Replace existing 2 No. dwellings with 1 No. dwelling & detached garage to include solar panels(resubmisison following WA/109/16/PL). This application may affect the setting of a listed building.

Church Farm Bungalows Binsted Lane Binsted

Thank you for your internet representation made on 2nd November 2017 which has been recorded as '**an objection**' with the comments as follows:

DRAWING NUMBER  
2088/02B

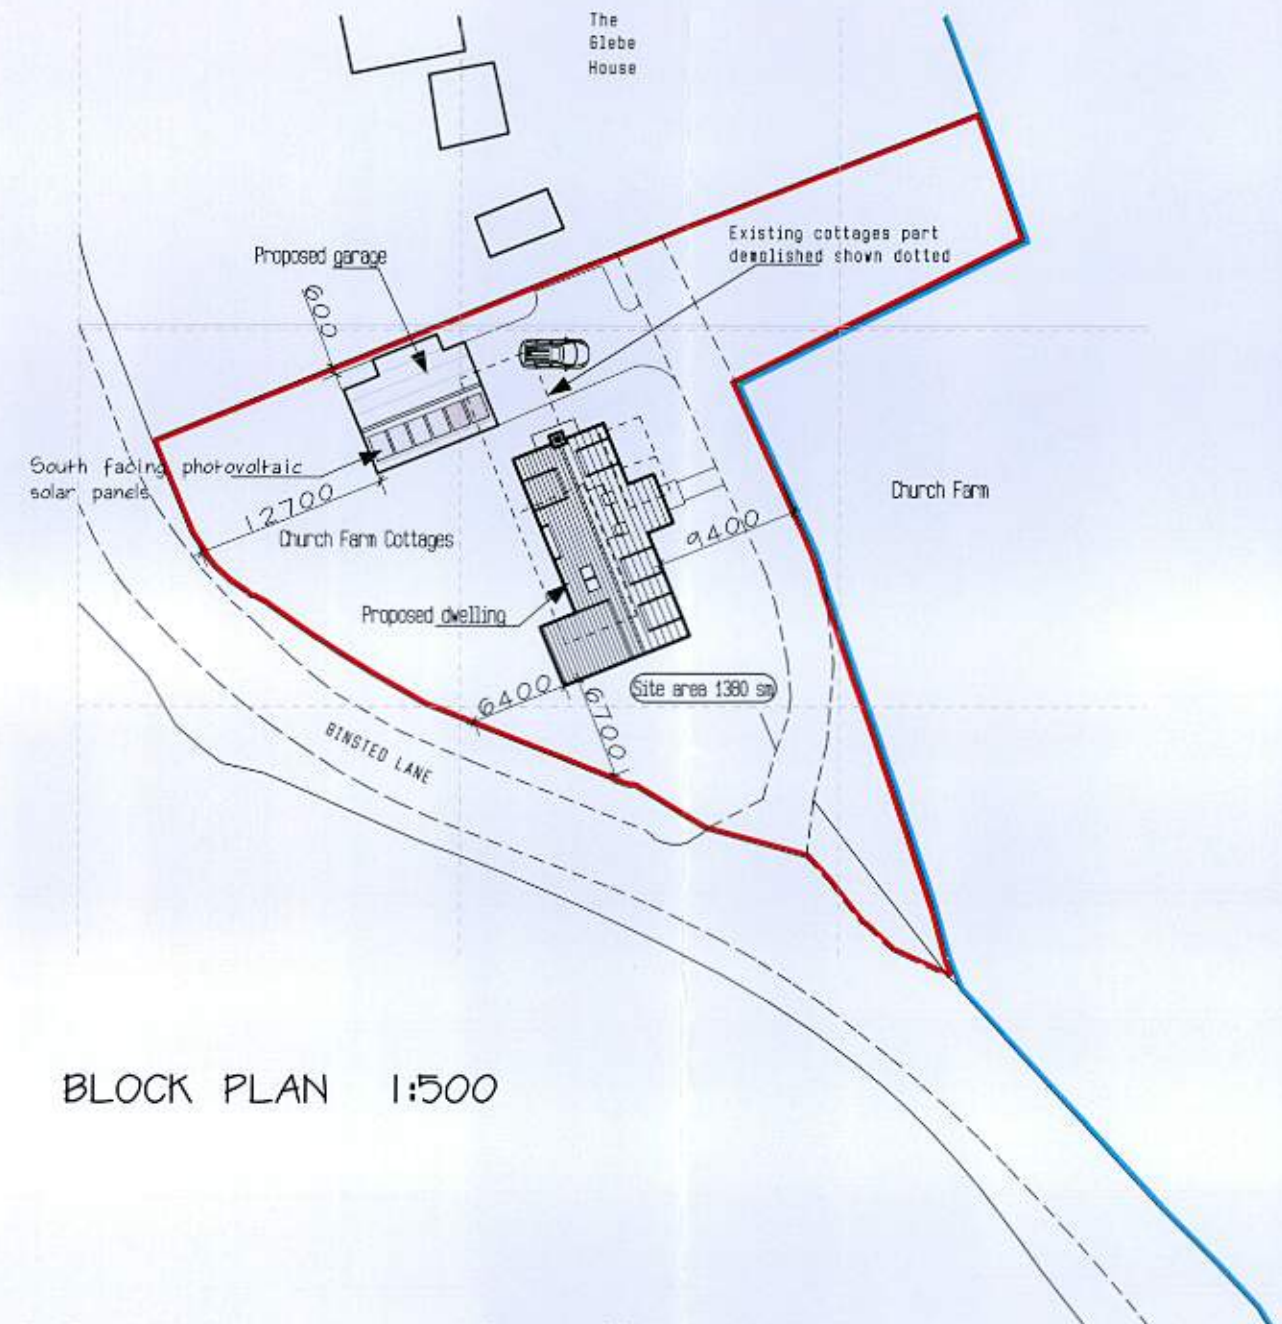
*I am objecting against the re-submission Application
WA/109/16/PL. This involves moving the proposed house 2.5
Metres forward of the existing foundation of the previous
dwellings. This will result in the proposed house being 2.5 metres closer to the shared
access drive. The result of which
would have two negative effects to Glebe House. It would affect the setting of a listed
property as it would be sited in front of Glebe House. We would then lose the privacy of
our
rear garden, which is also our main entrance,
It is our strong feeling that the house should not be moved
forward and stays on the footprint of the existing foundations.
John Harding*
